OWNER/DEVELOPER: SR LAND, LLC
20 BOULDER CRESCENT, SUITE 201
COLORADO SPRINGS, CO 80903
JAMES F. MORLEY (719) 471-1742

1	COVER SHEET
2	NOTES
3-12	STORM SEWER PLANS
13-14	TEMPORARY DITCH PLAN & PROFILE
15	POND W-5
16-19	POND DETAILS
20	POND W-4
21-23	POND DETAILS
24-26	DETAIL SHEET

STERLING RANCH FILING NO.2

AS-BUILT PLANS
2026-05-26
EPC SF-20-15

**STRM_19 PROFILE
STA 0+00.00 TO 13+29.82
PUBLIC**

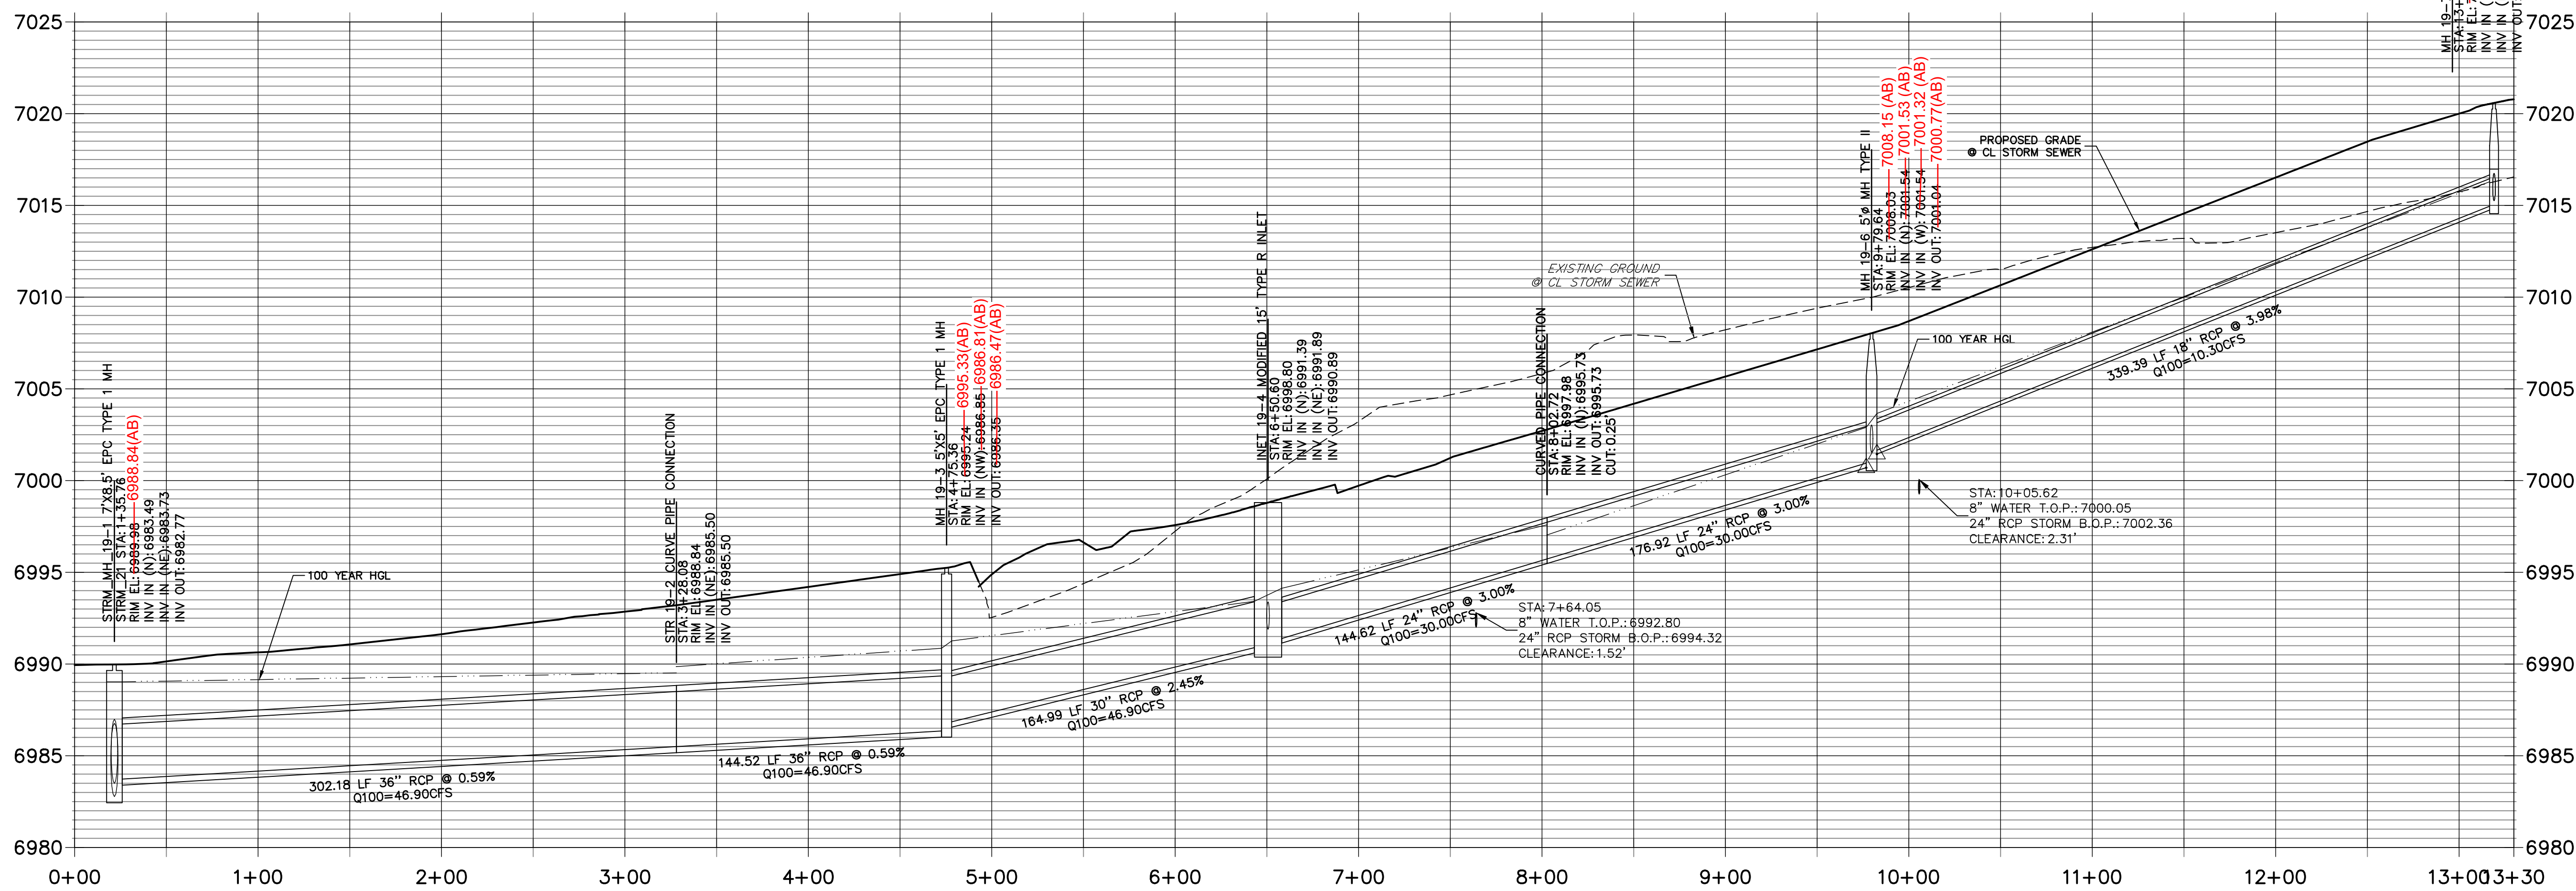
Overall quantities (public) as listed on certification letter are not matching with what is shown on CD's. If there is more of the system which is public, please revise on the CD's. Update quantities on certification letter as needed.

**FULL SPECTRUM DETENTION
POND W-5 FOREBAY PLAN**
NOT TO SCALE

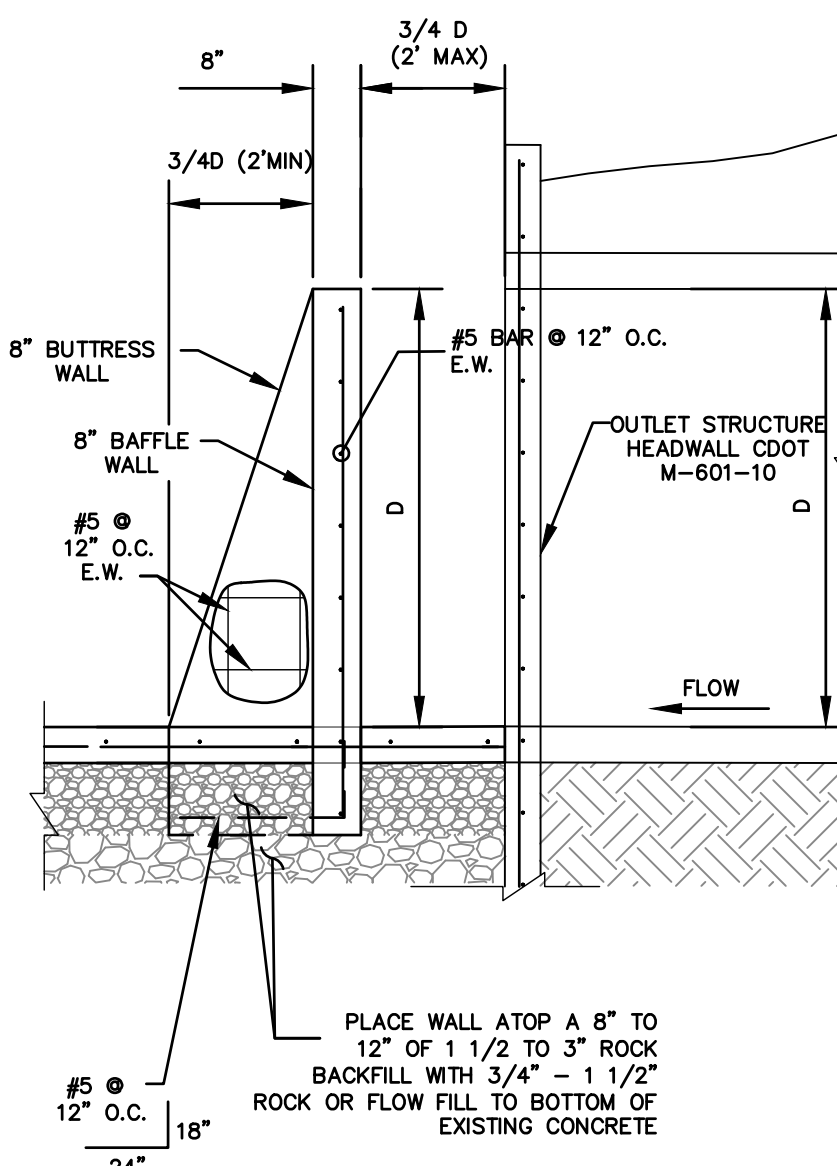
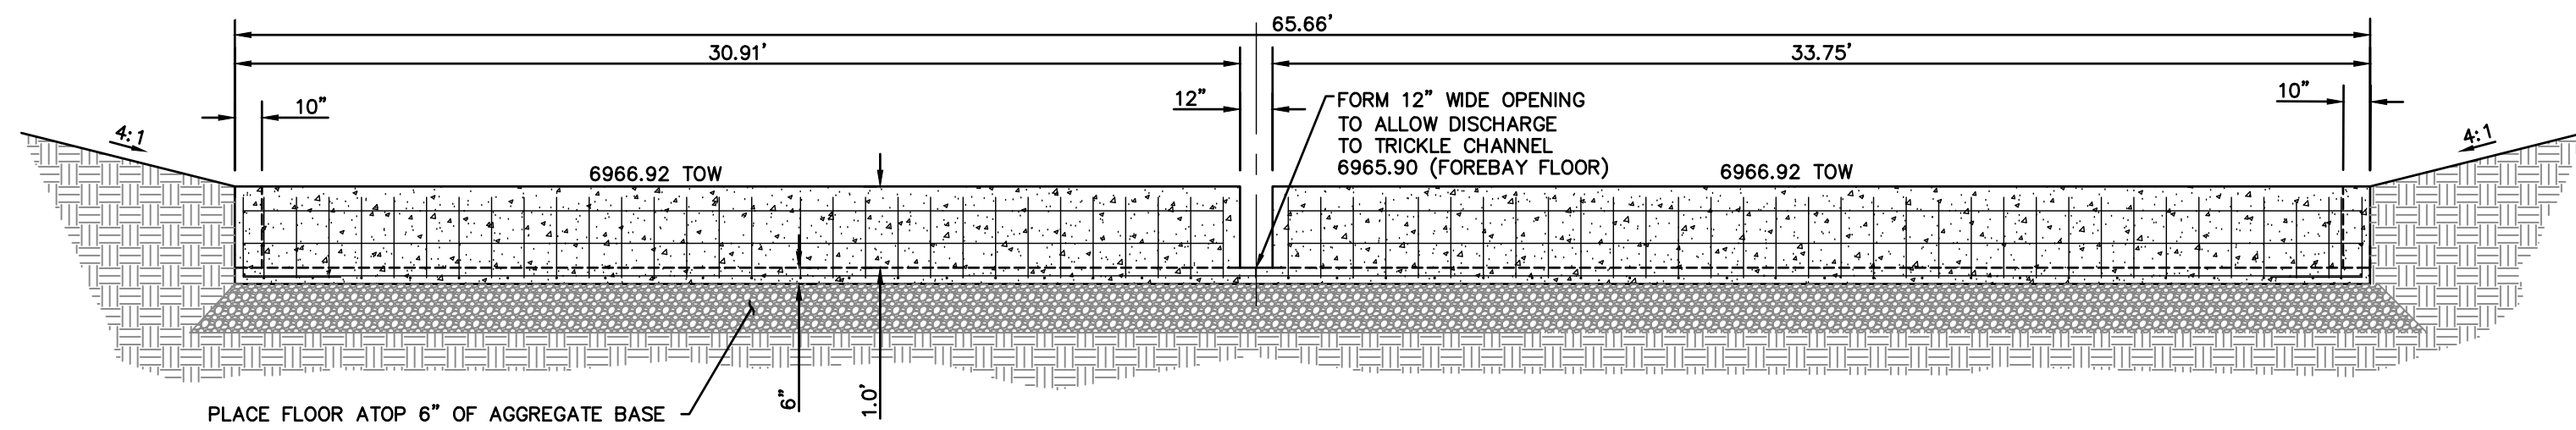
Stormwater PA Punchlist item:
Show the northwest forebay dimensions on the as-built drawings, since they are not shown on the approved plans.
Additionally, check the FDR for sizing calcs of that forebay. If they are not in there, please provide them with the other as-built pond calcs.

Stormwater PA Punchlist item:
The pond bottom is saturated with groundwater. Discuss mitigation options with project engineer and propose a solution to EPC DPW.
All-Terrain - have you guys been out there to look at this and/or discussed this with Chaz yet?

STORM 23 - 84" OUTFALL STILLING BASIN W/ HEADWALL & WINGWALL
SCALE: 1" = 4'

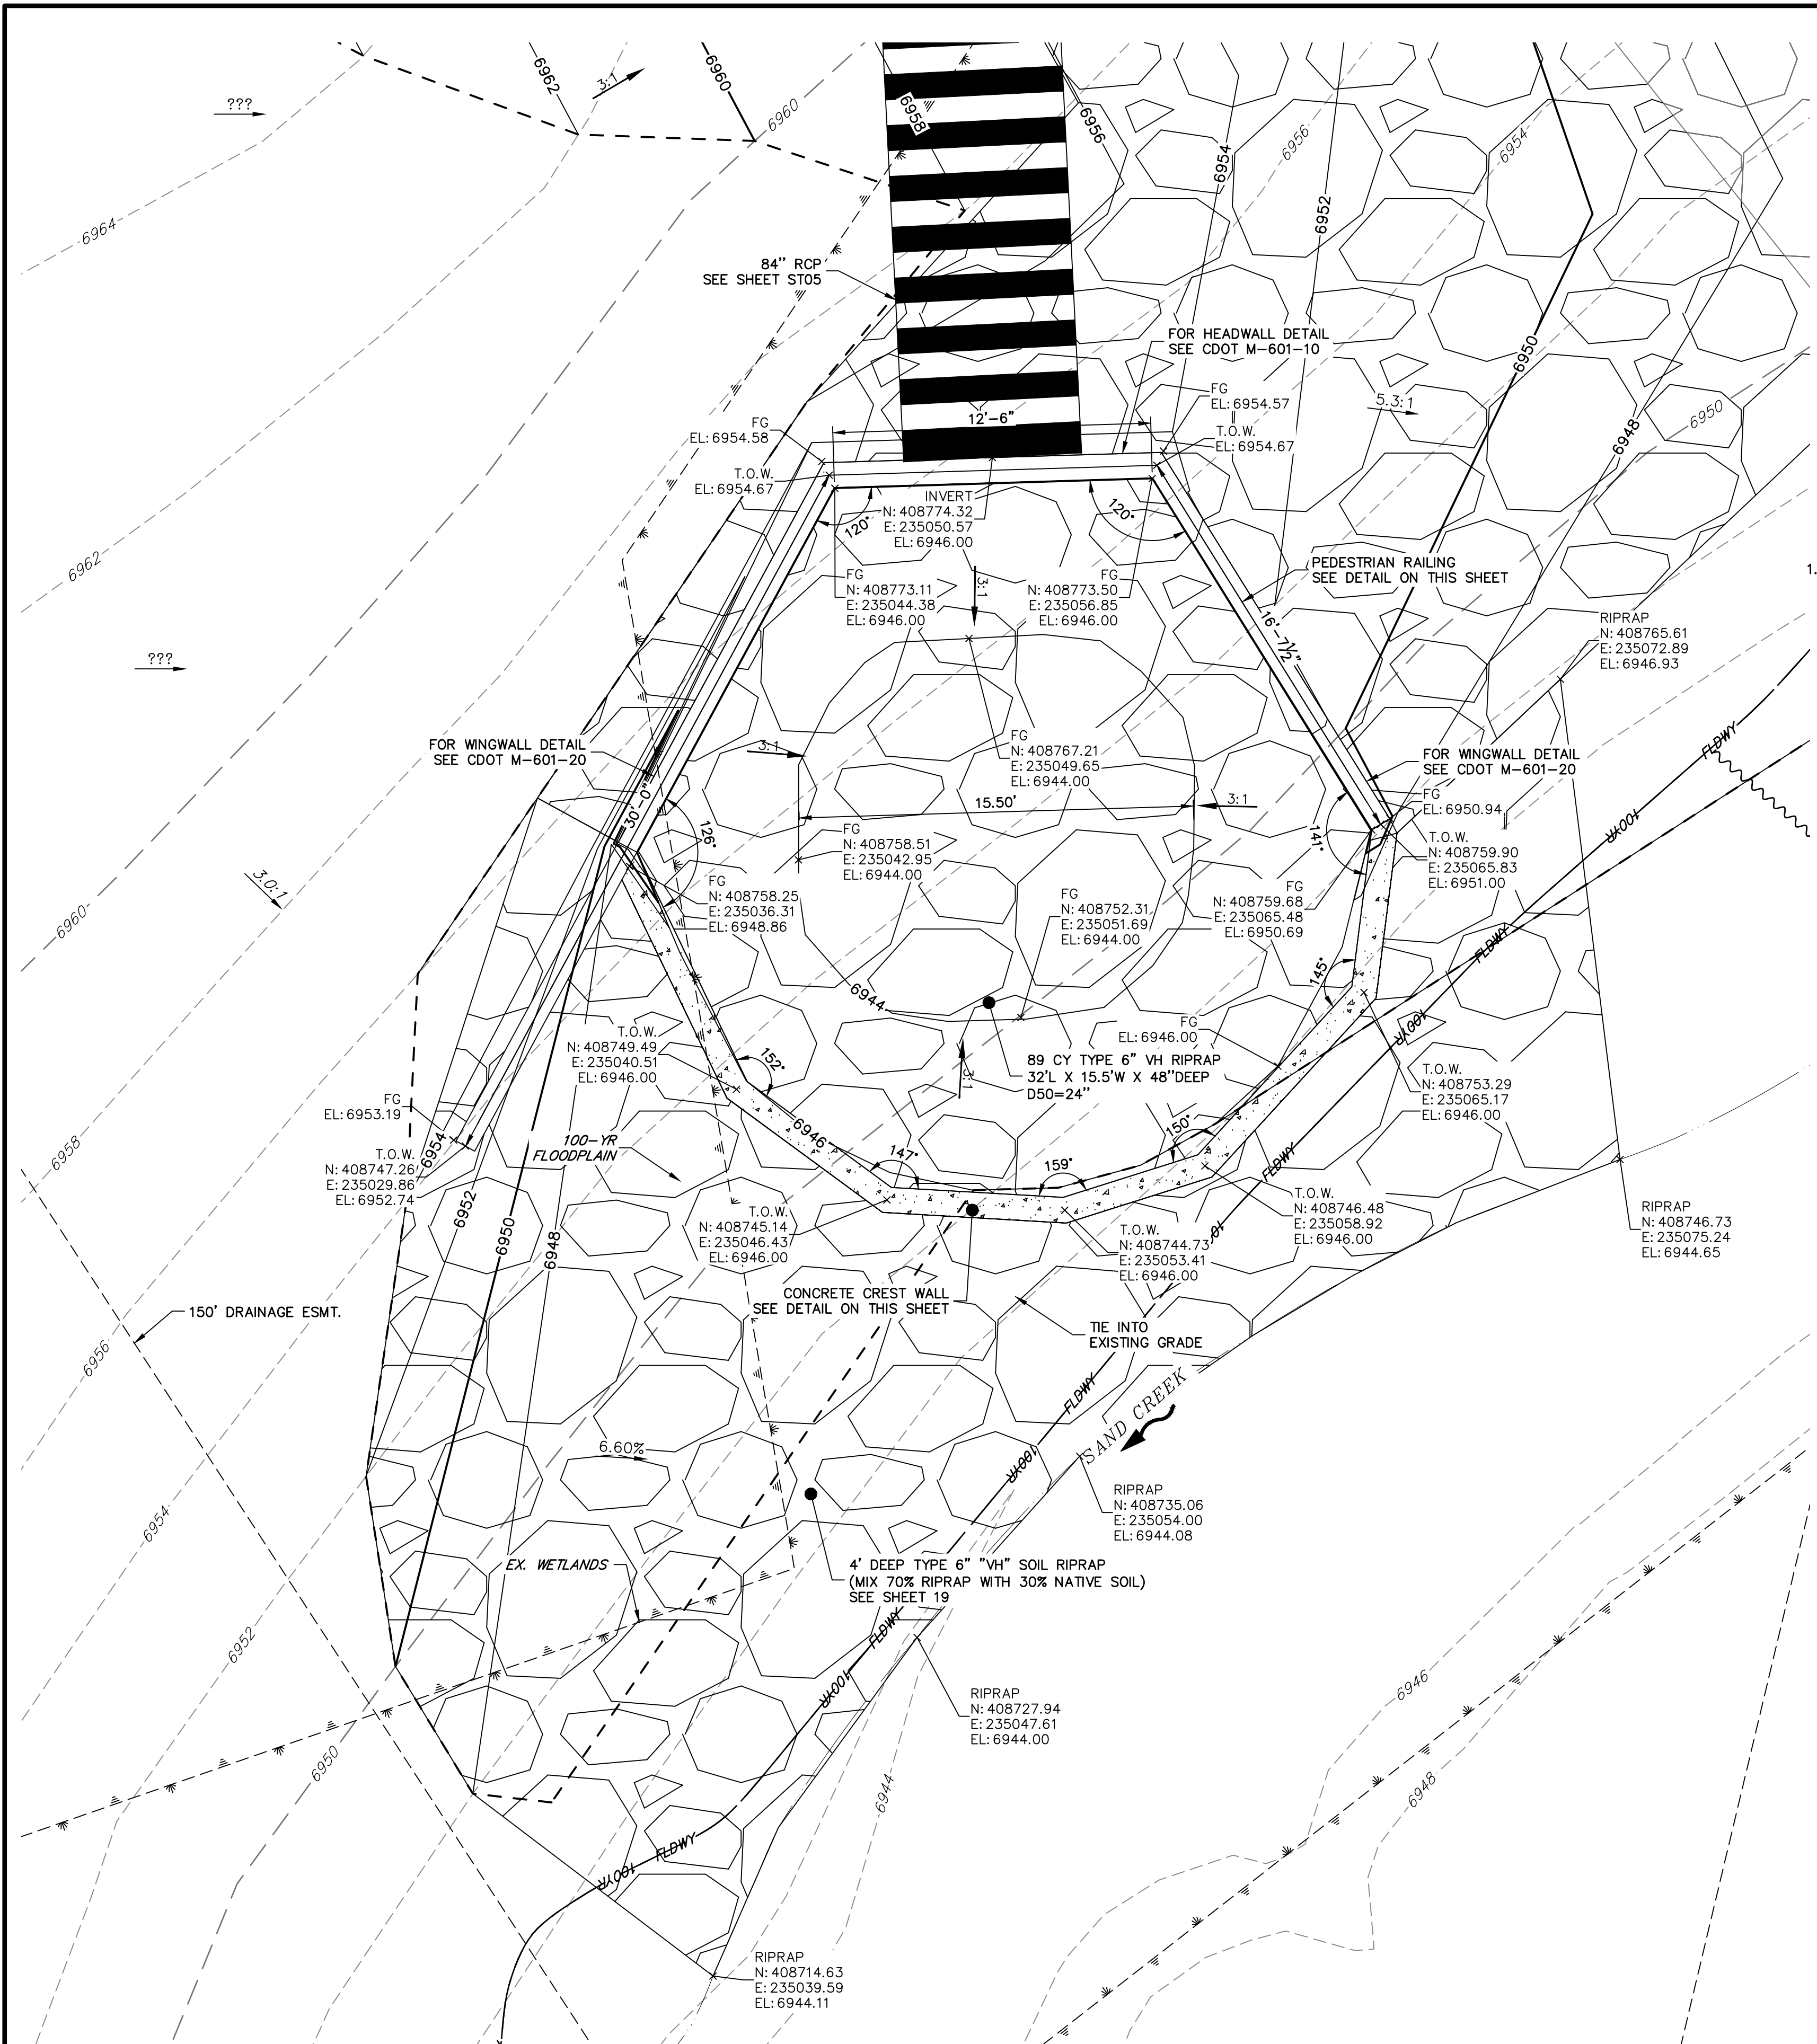
Stormwater PA Punchlist item:
Remove sediment from the stilling basin at the pond outfall.
Stilling basin is to be 2ft deep per plans but is currently completely filled in with sediment.
All-Terrain - Chaz doesn't want to clean it out, especially because it'd be very hard to access to do this work. Can you look at running calcs on a flat apron instead of a stilling basin and let me know if it works? And if it does, this sheet could be redlined accordingly (but let me first discuss internally if we'd even accept this as-is, but it will be helpful to know if the calcs work first).
